# SWPPP COMPLIANCE INSPECTION REPORT

Date of Inspection	Monday, September 23, 2019
Project	Top Golf ABQ
Location	1600 Desert Surf Loop

NPDES #	NMR 1001XF/NMR 1001XJ/NMR 1002AK
Permit Type	Construction General Permit
Inspection Type	14 day

SEDIMENTATION/SILT FENCE WITH WIRE SUPPORT

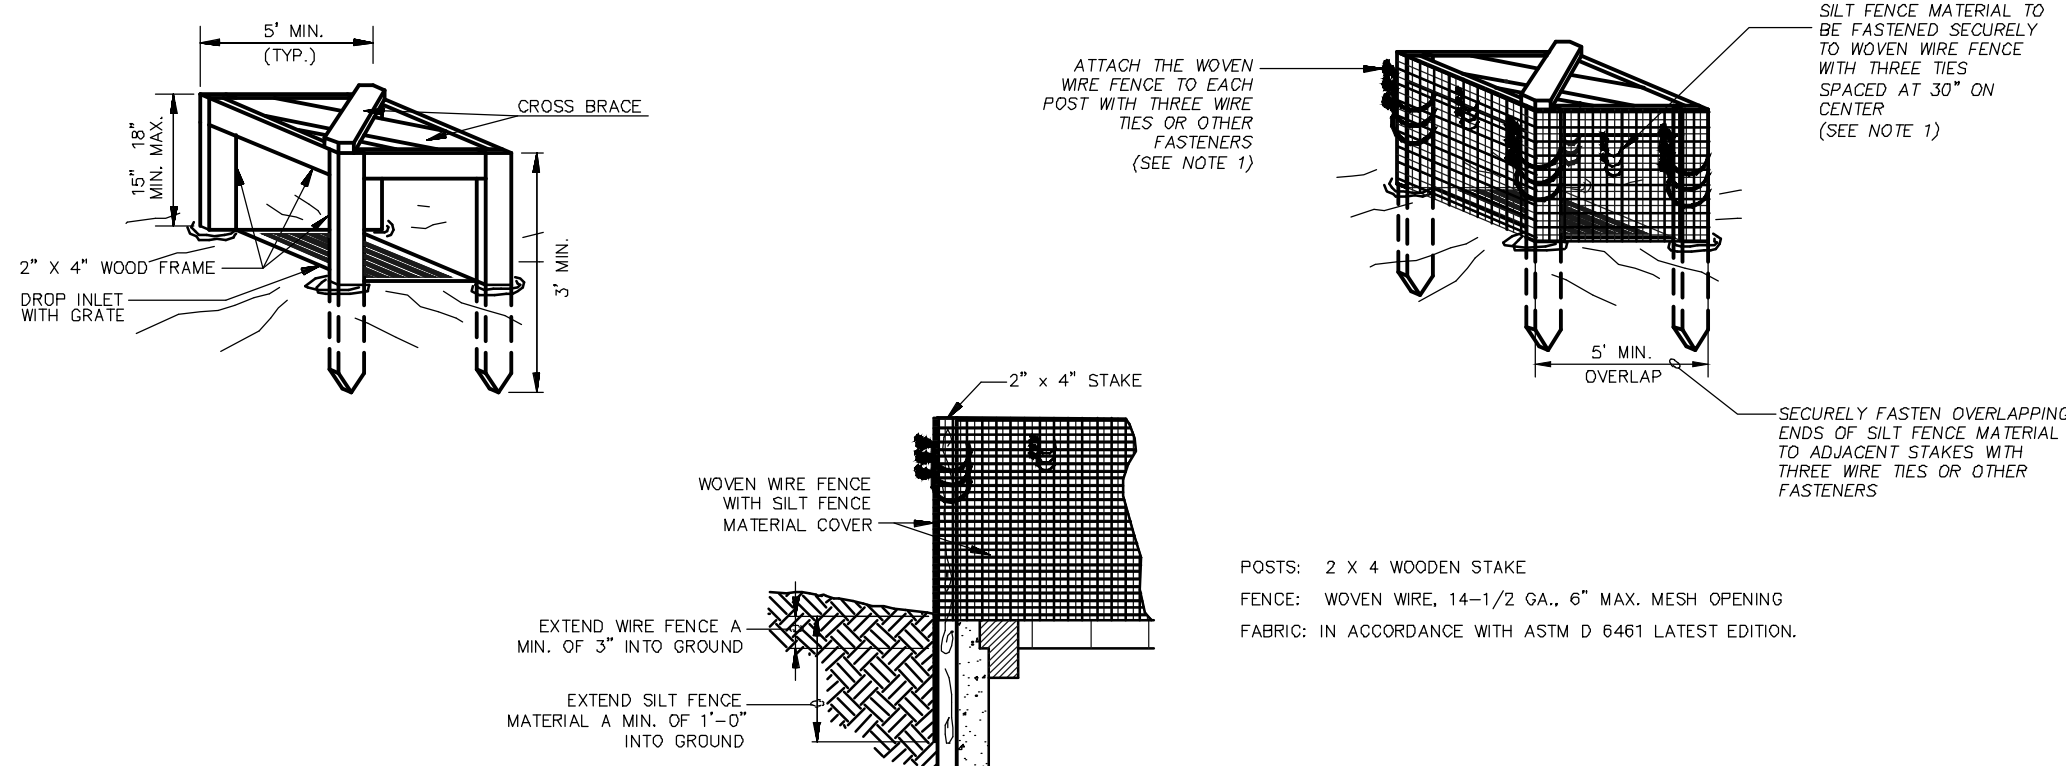
Replace Silt Fencing

Replace Silt Fencing

SWPPP INFORMATION SIGN

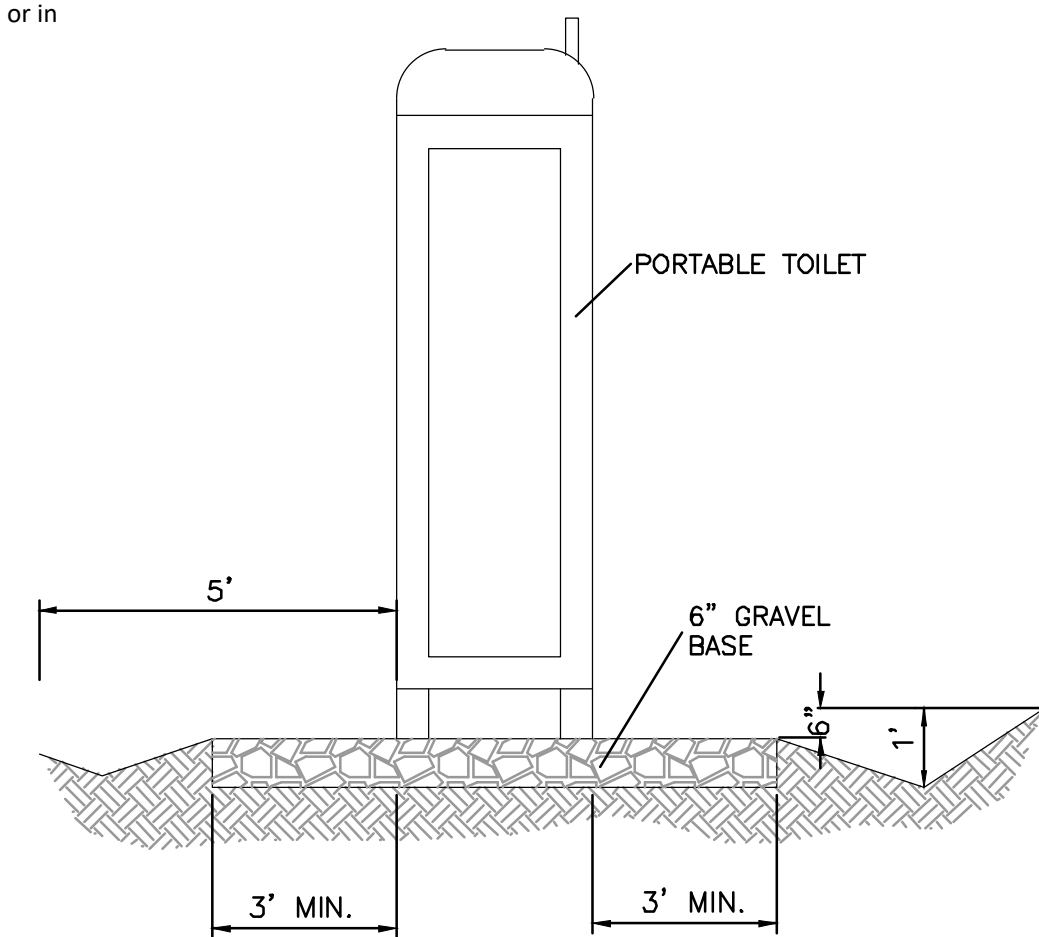
SWPPP Item	Compliance	Action Required	Notes:
Is the SWPPP Notice properly posted with correct information?	No	Post all NPDES Permit #'s on Board	Posting is at north entrance
Are the Limits of Disturbance properly protected?	No	Replace silt fencing removed for shoring operations, access to pond and H/C ramps	Silt fencing should be replaced behind recent ramp construction on Desert Surf Dr
Are all Natural Resources or boundary with the Waters of The United States properly protected with barriers or BMP's?	N/A	None	None
Are Construction Exits properly controlling sediment track out from the site?	No	Upsize rock at existing south exit. A new rock exit is now required at the earth protection berm on the newly constructed access roadway. Sweep sediment from public roadway when observed.	All site exits should have controls installed and maintained to control track out. Track out should be swept daily.

CONSTRUCTION EXIT

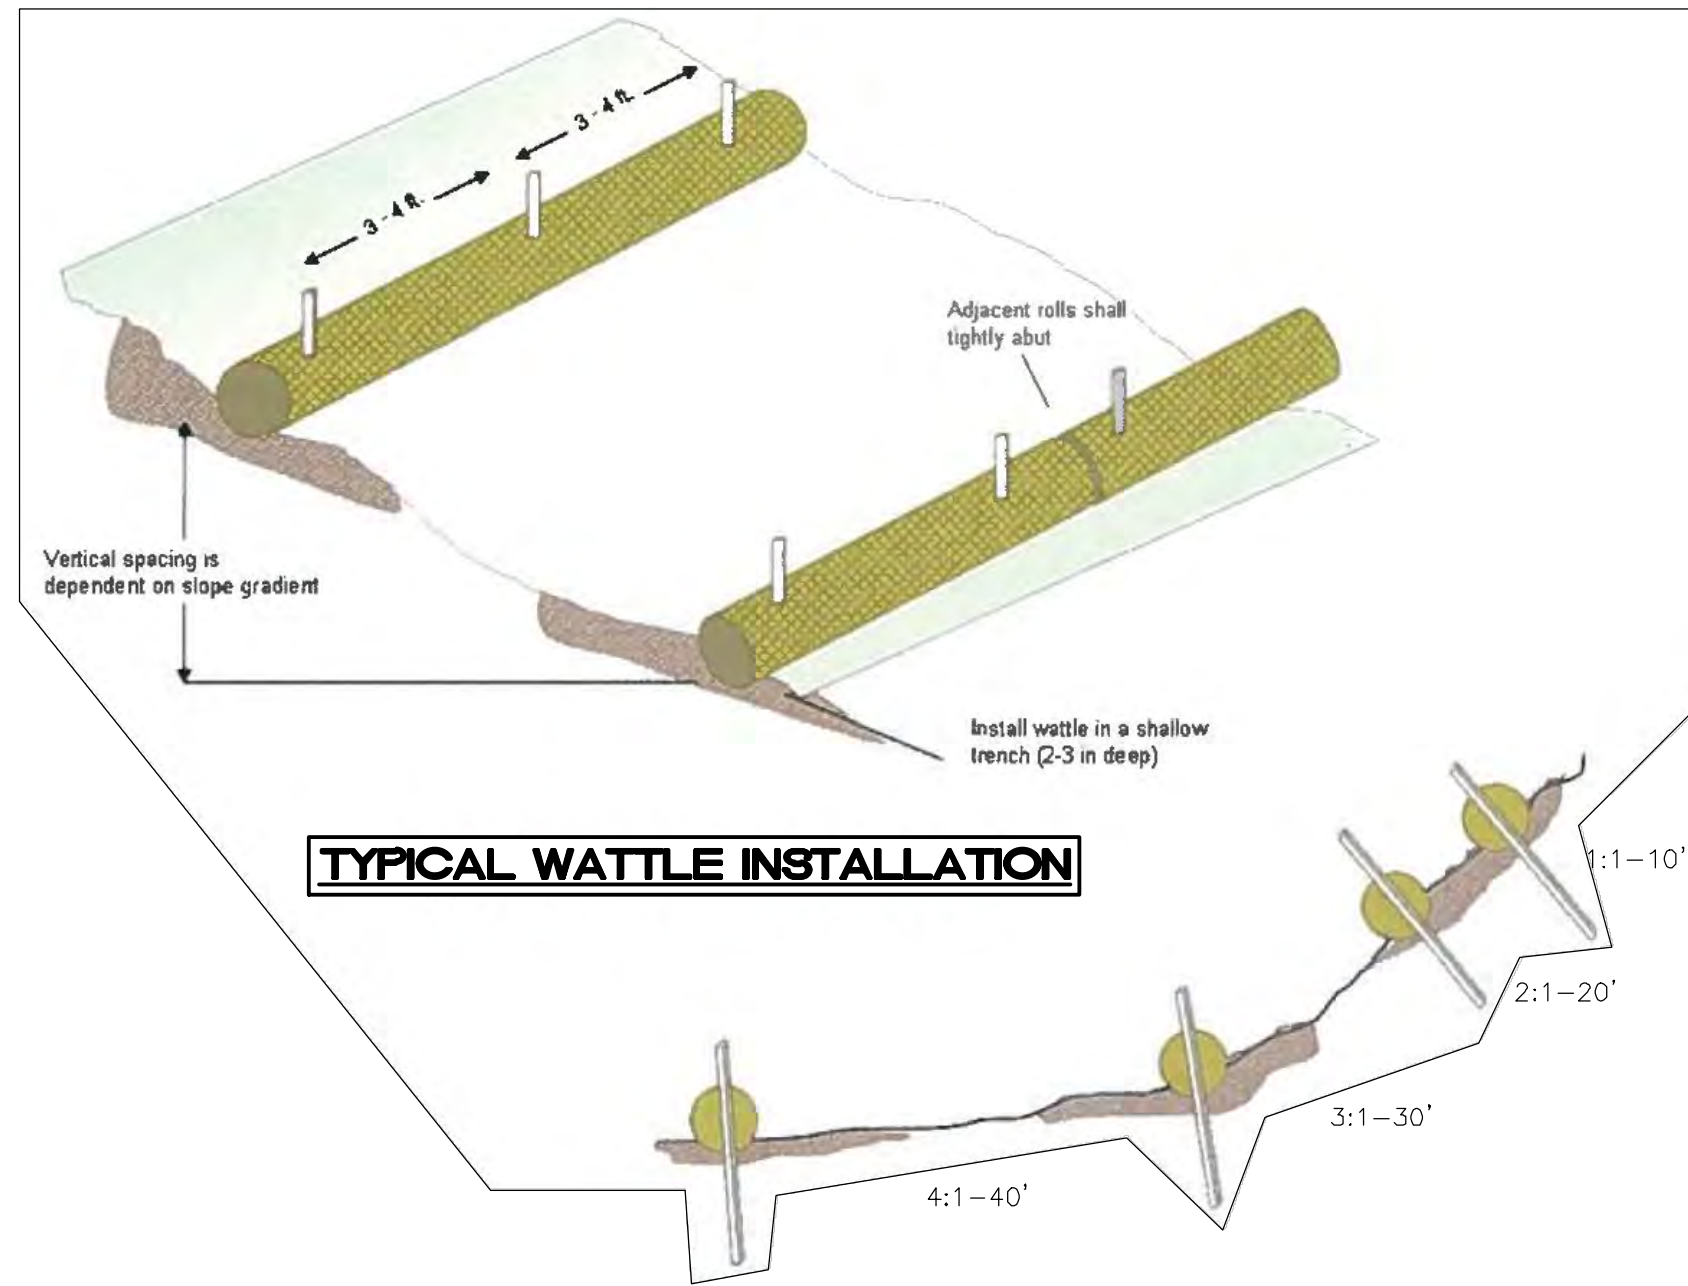
POLLUTION PREVENTION, SEDIMENT AND EROSION CONTROLS			
List Any BMP's Or Controls That Require Maintenance or Corrective Actions?			
Control	Location	Issue	Maintenance or Corrective Action?
Entrance/exit areas require additional rock to control track out. Earth berm across access road needs controls placed	Desert Surf/ New access to building pad	Sediment discharge. Track out clean up	Maintenance
Install additional wattles on all slopes per plan	All Slopes	Reduce run off velocity and erosion; protect completed work	6th Notice
Large pond area requires permanent stabilization when all activities are completed	Offsite Pond	Slope erosion and discharge erosion was observed	Maintenance
INSPECTION COMMENTS OR OTHER			
Note all SWPPP BMP's repairs, replacement and additions on SWPPP ESC Plan

North exit requires larger rock to control sediment track out

Add wattles or replace with base course. Add rock exit

TYPICAL WATTLE INSTALLATION

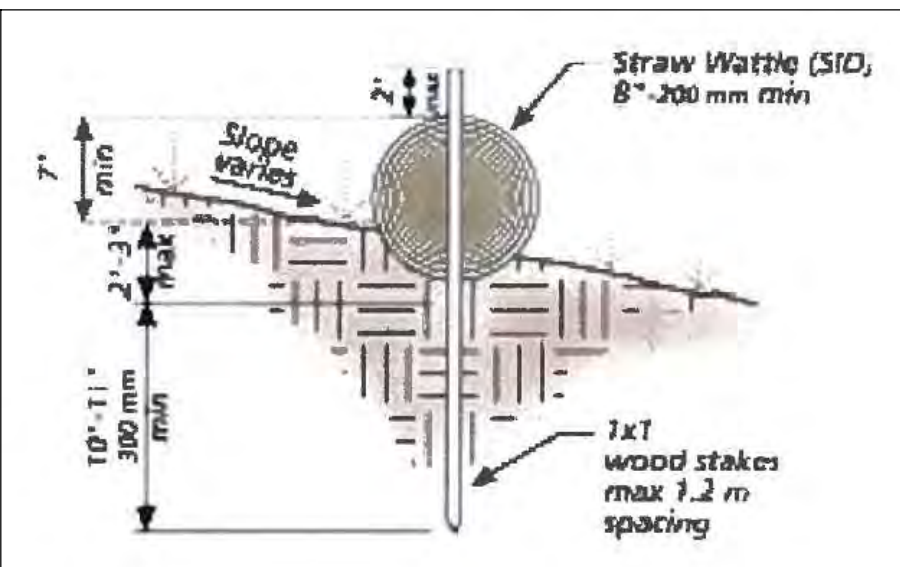
Are there any stockpiles inactive for 14 days or more that require Temporary or Permanent Stabilization installed?	N/A	None	None
Do all steep slopes have proper base and intermediate controls in place?	No	Additional wattles are required to control erosion and protect completed work	Additional wattles are should be installed per SWPPP Plan details on all steep slopes.
Are Wash Out Facilities available and clearly marked ?	Yes	None	None
Is Trash and Litter being properly disposed?	Yes	None	None
Are Vehicles and Equipment free of leaks and a Spill Kit available onsite?	Yes	None	None
Are Dust Control practices in use adequate?	Yes	None	Water suppression is in use.
Is there any evidence of chemical or other contaminant spills onsite?	Yes	None	No chemicals or contaminants were observed stored onsite
Are all construction materials with potential pollutants covered or stored properly?	N/A	None	No adverse materials were observed as stored onsite
